DELEGATED DECISION FOR DISCHARGE OF CONDITION A1 - NOTIFICATION OF A PROPOSED DEVELOPMENT UNDER LOCAL OR PRIVATE ACTS OR ORDER

Reference no. 2026/CL/90919/W

Description	Prior approval for alterations to bridge MVL3/48
--------------------	---

Proposed Section B-B
Scale 1:50

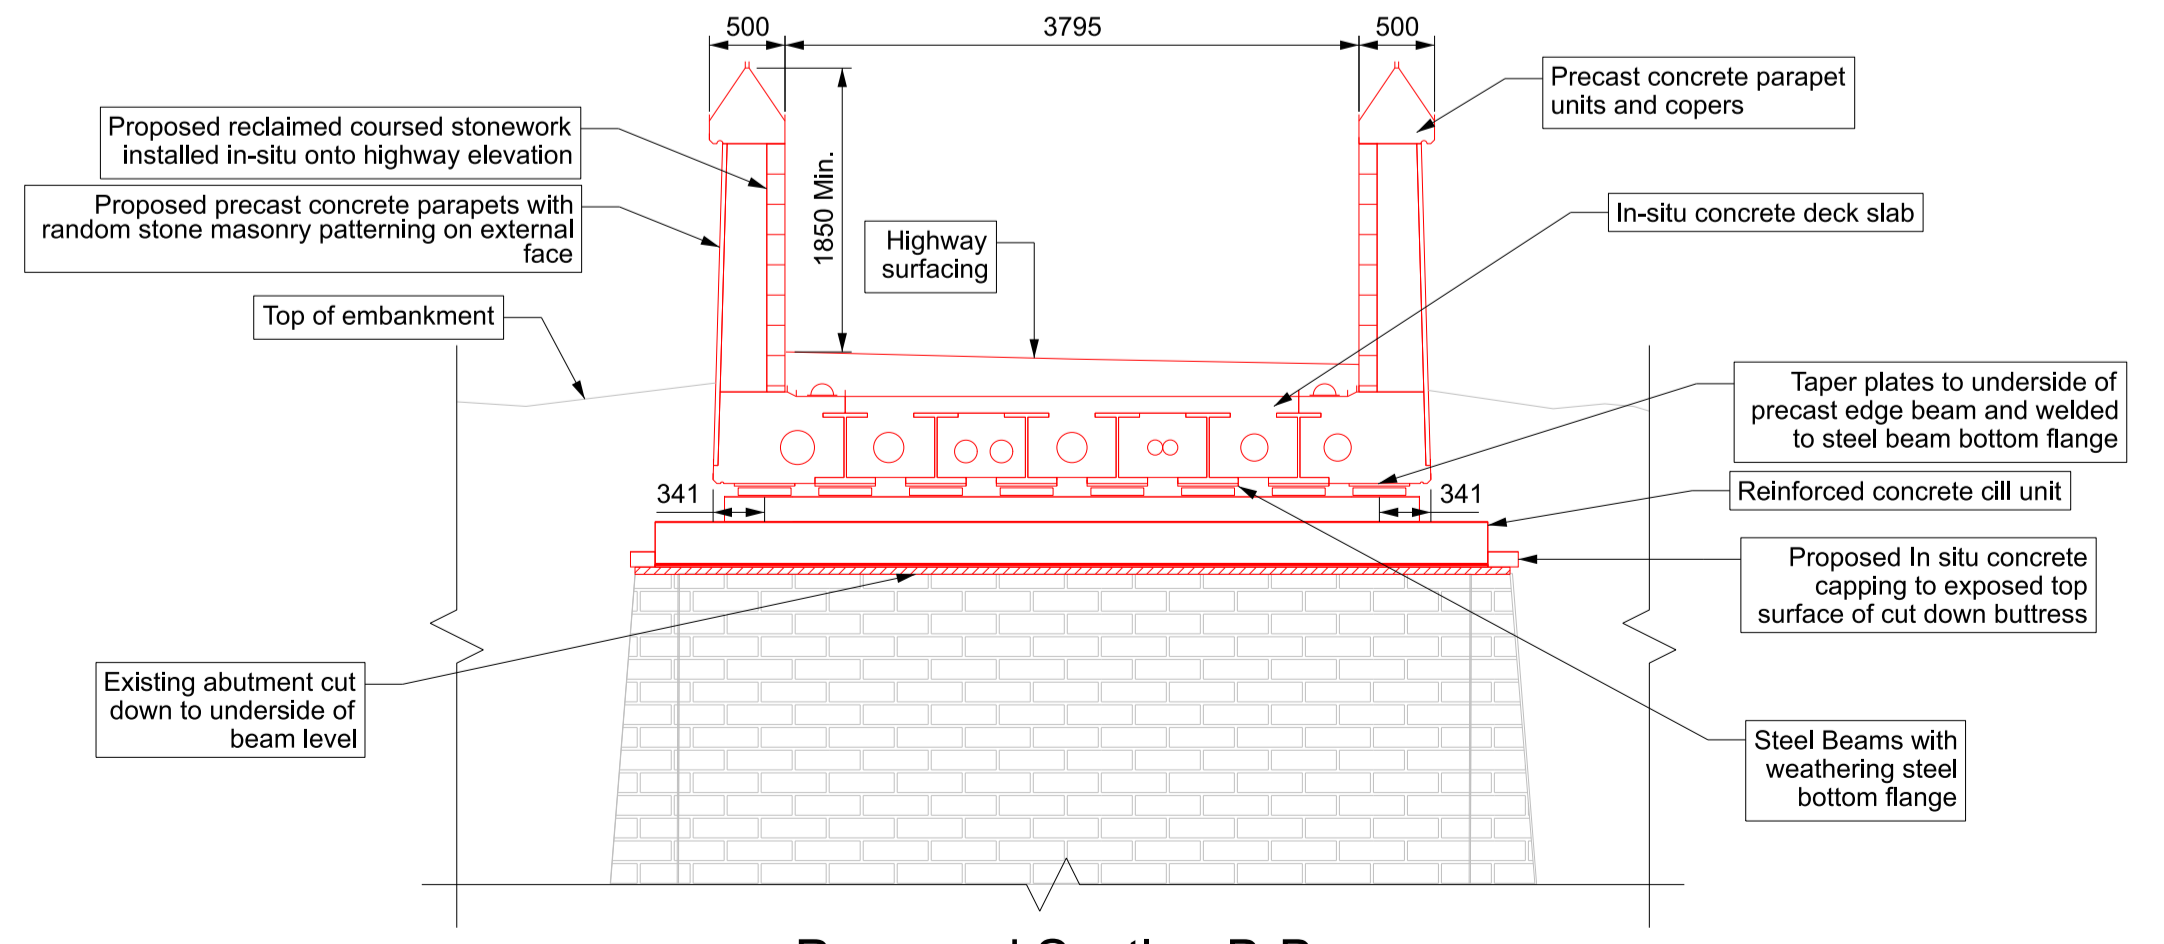
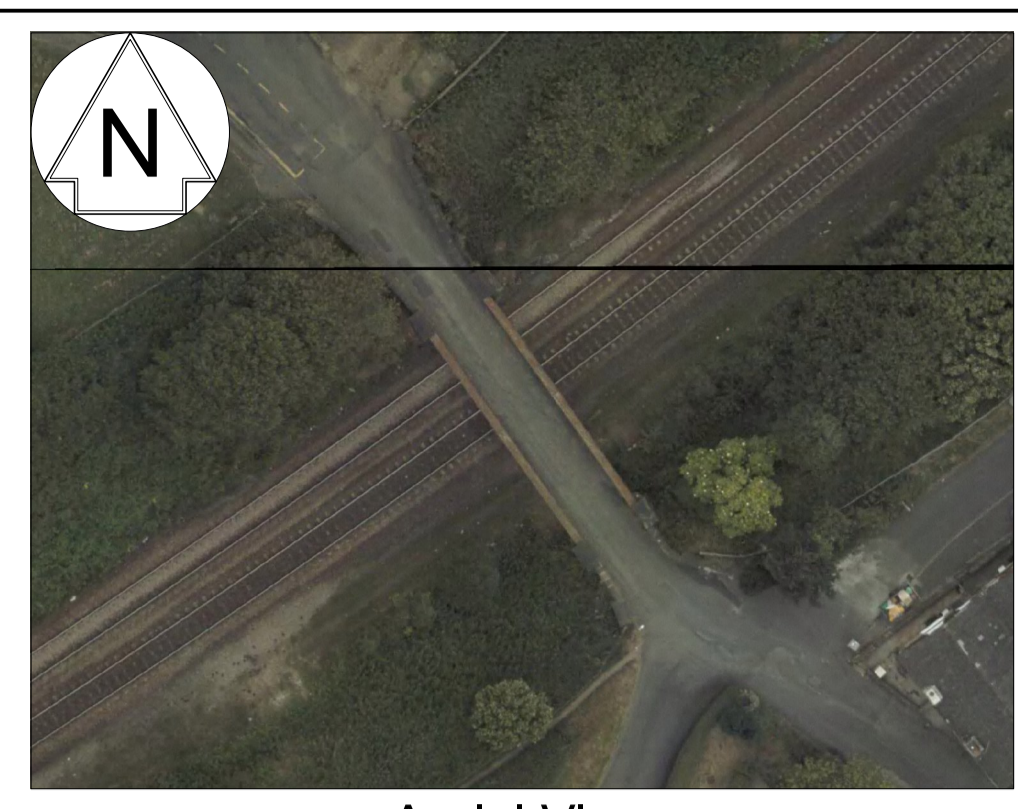
The bridge carries Grange Street and connects into an informal five-arm junction at the north that serves the surrounding residential streets, including Plains, Dirker Drive and Dirker Avenue. It is noted that there is a proposed reduction in width of the bridge of approximately 30mm.

Drawing Title: **Prior Approval - MVL3/48 Grange Street - Existing and Proposed Elevations and Sections**

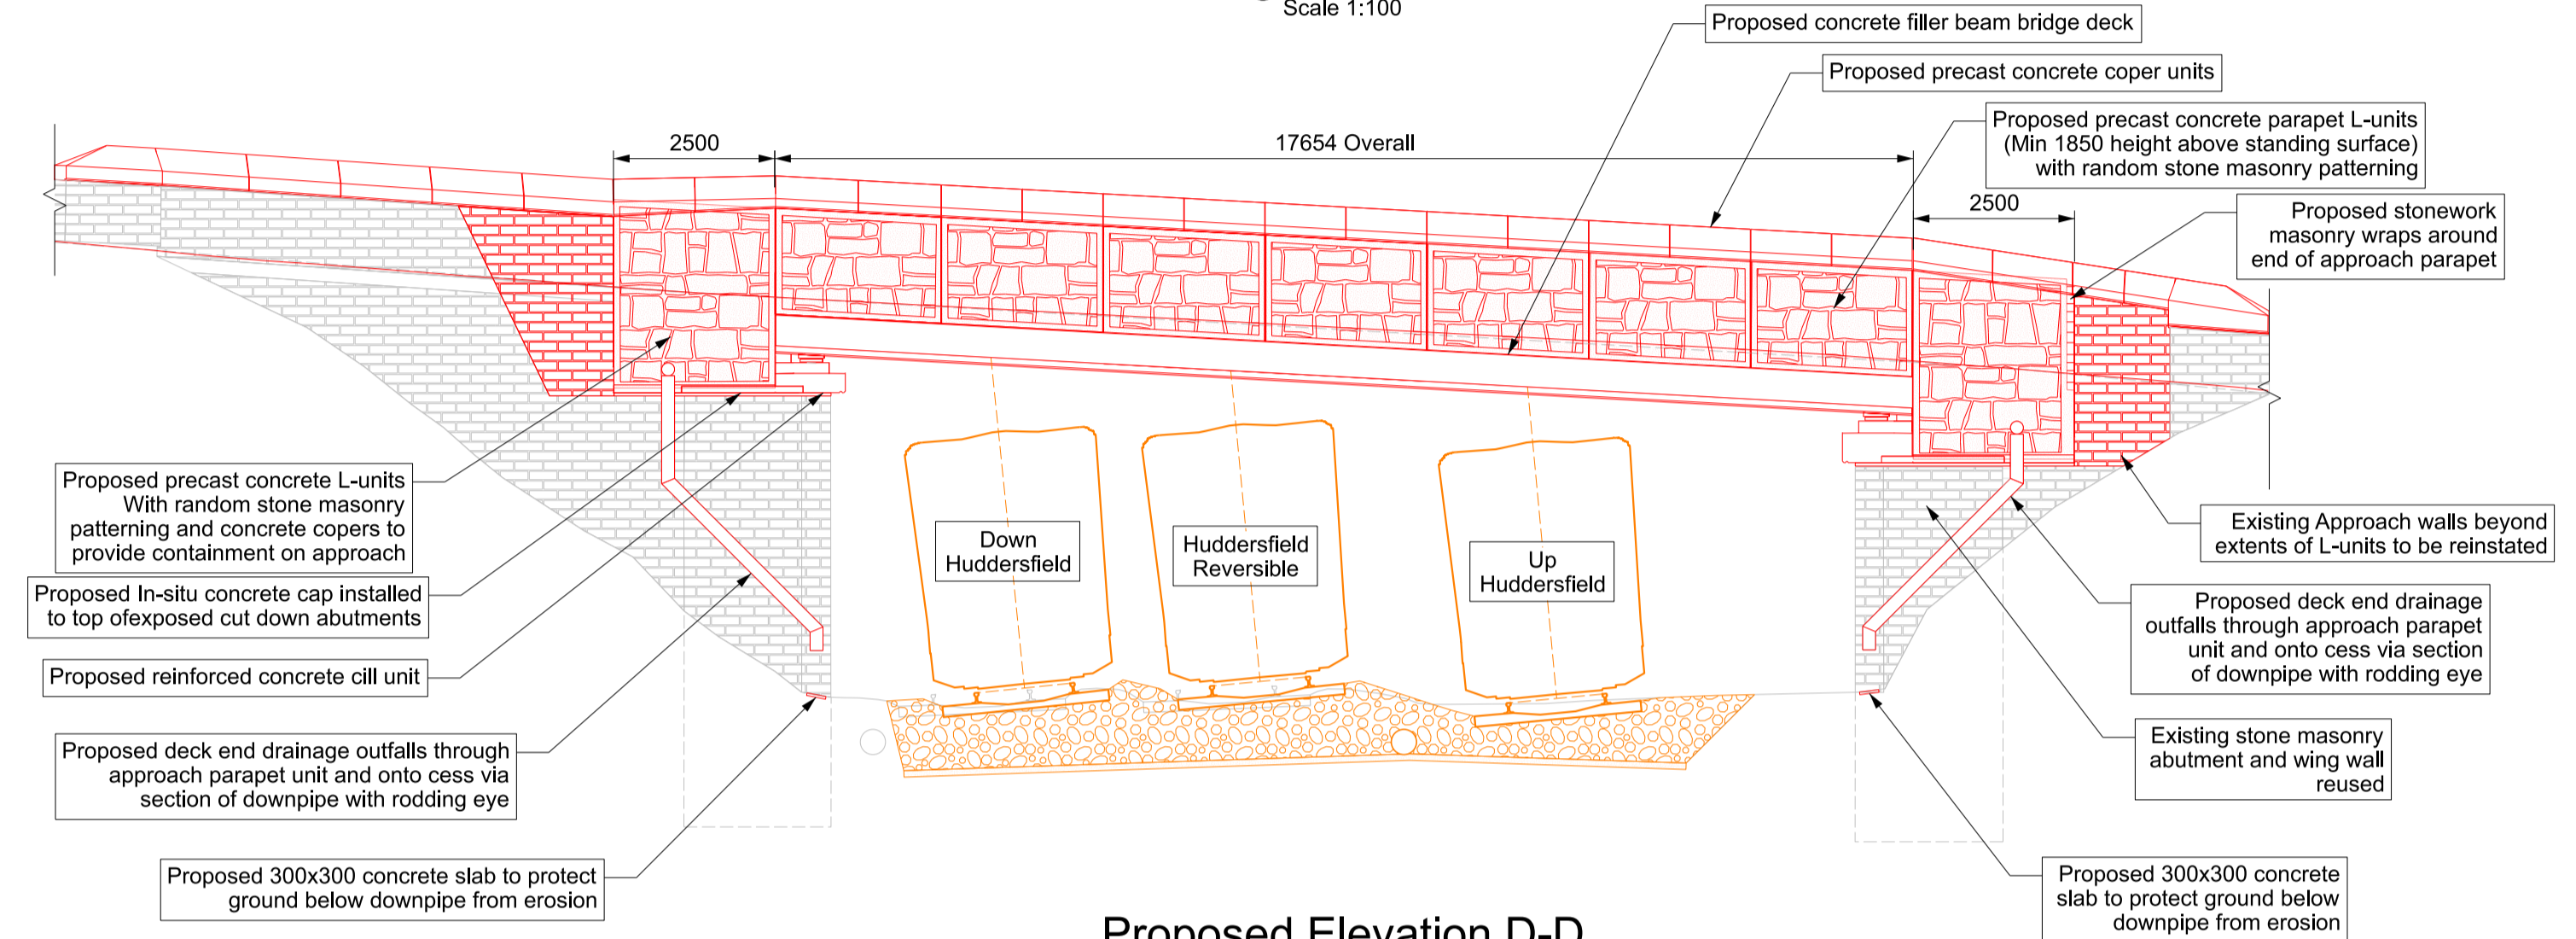
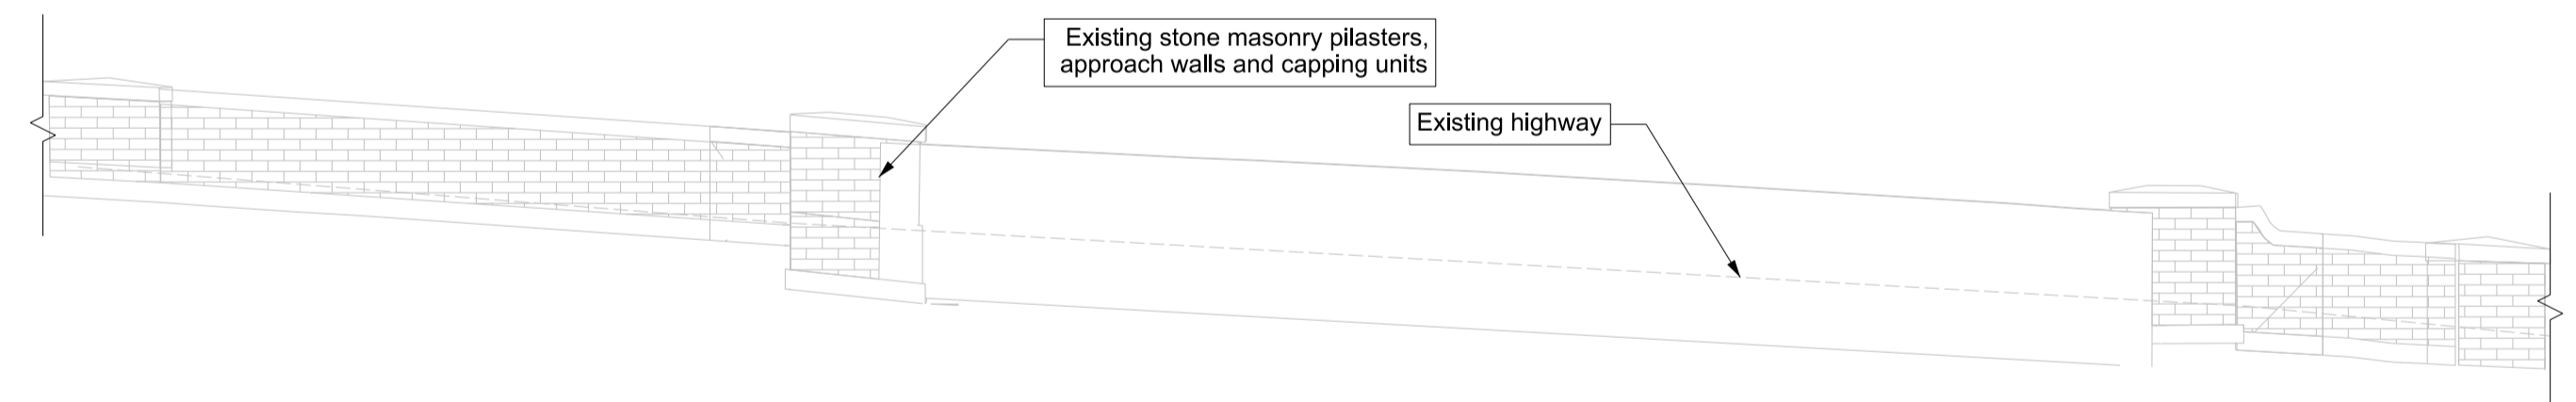
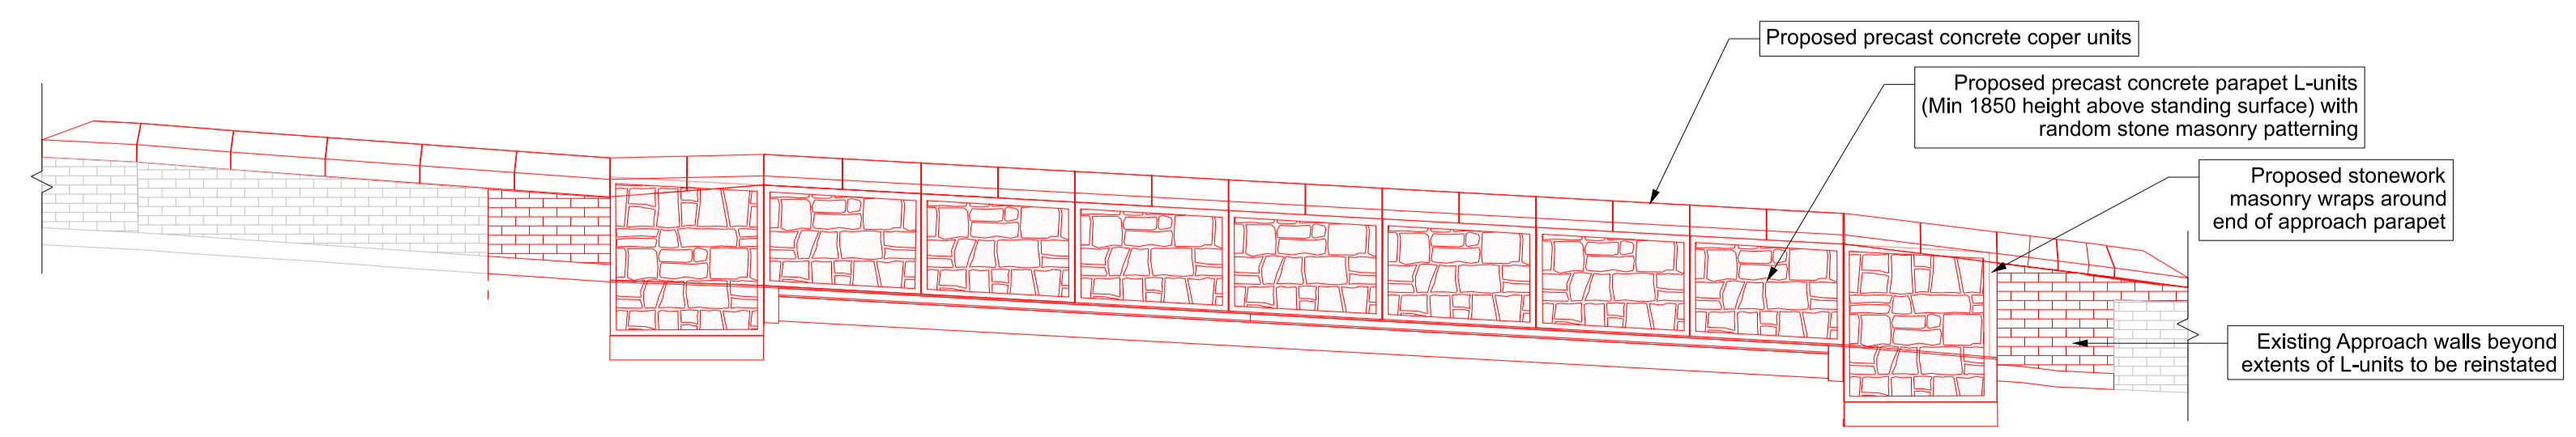
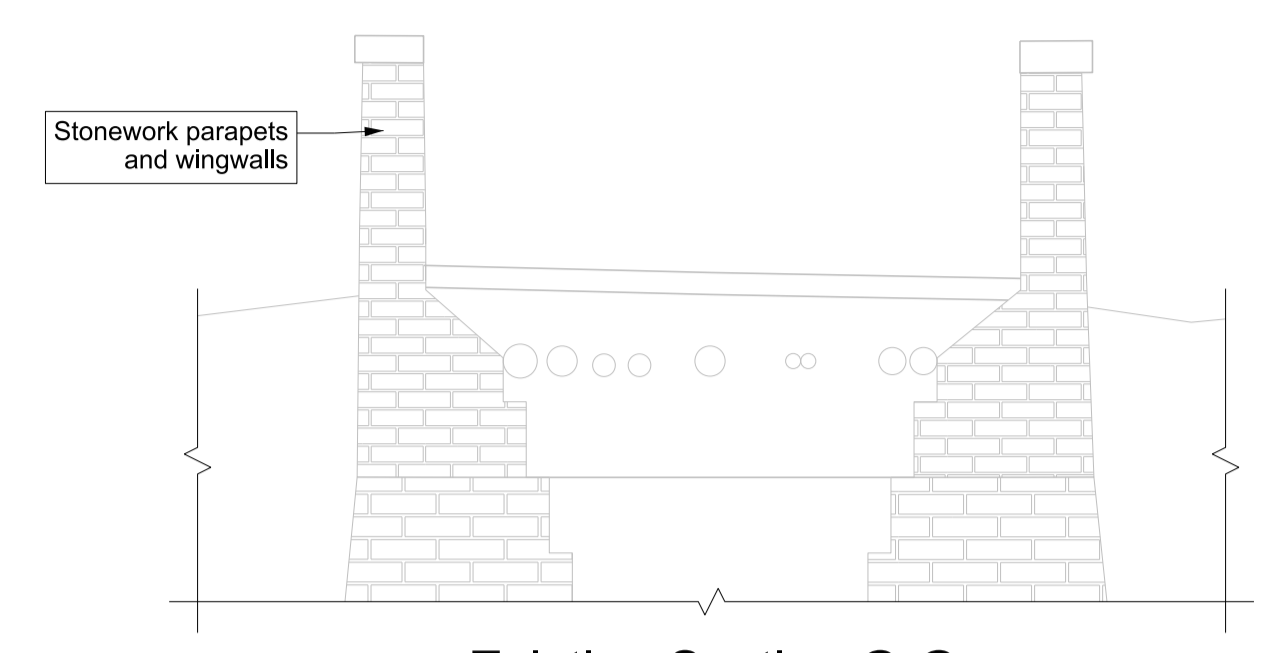
- *The pre-cast concrete L-units shall be finished with natural stone cladding design pattern to match the natural coursed stones below. The concrete shall match the existing natural stones by colour, texture and coursing.*
- *The GRP handrail shall be finished in a black or green colour*

case concrete with stone masonry patterning is proposed. Conservation and Design officers have advised that this may not be appropriate. The applicant has advised that they are unable to provide alternative materials and design details at this stage in the process and therefore suggested a condition for the submission of parapet materials, design and finish which is considered acceptable. As such, there is no objection to the proposed works, subject to the application of suitably worded conditions for the submission of parapet materials and the finish of the proposed handrails.

1. Notwithstanding the submitted plans, a sample of the parapet finish[es] shall be submitted to and approved by the Local Planning Authority, prior to their installation. The external treatment of the parapet finish[es] shall reflect the retained stonework of the bridge in terms of colour, texture, finish and coursing.
Reason: In the interests of visual amenity and the conservation of the Historic Environment and to accord with Policies LP24 and LP35 of the Kirklees Local Plan.
